From: Paul Cann
Sent: 16 February 2018 15:28
To: Planning.Responses
Subject: RE: Planning Consultation on P/117/17/DOC

APPLICATION P/117/17/DOC

Site Address: Sefter Farm Pagham Road Pagham PO21 3PX

Description of Works: Application for approval of details reserved by condition imposed under planning permission P/76/16/PL relating to condition No. 15 (Surface water drainage scheme)

Archibald Shaw Limited		Page 1
One Little London Chichester Sussex PO19 1PP	SEFTER FARM PAGHAM POROUS CAR PARK	
Date Feb 2018 File porous car park.SRC	Designed By PF Checked By	
Micro Drainage	Source Control W.11.2

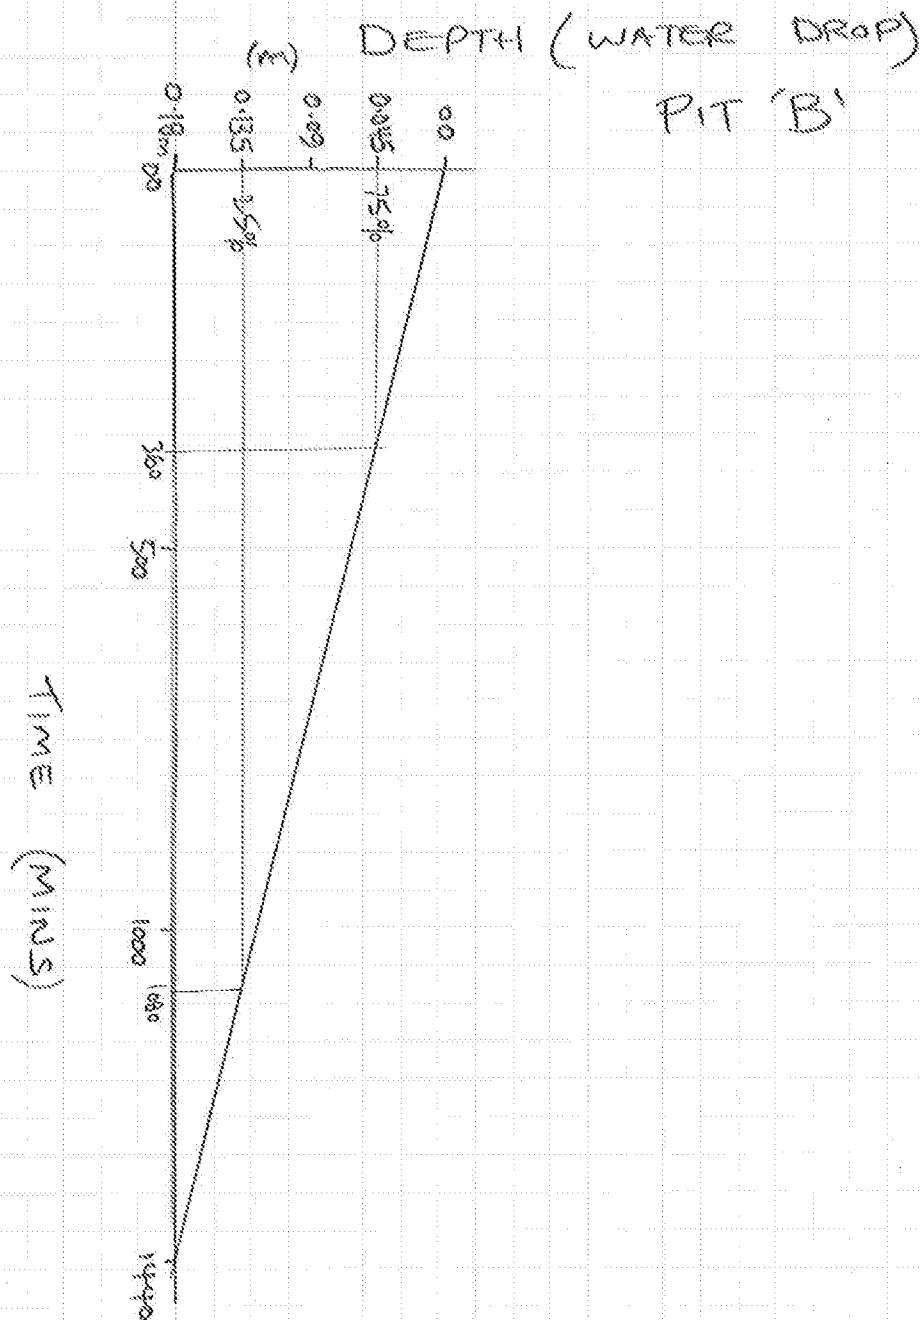
We are currently awaiting full details for the car park drainage including storage calculations/percolation test results, etc. Therefore, at this time I am unable to recommend discharge of the condition.
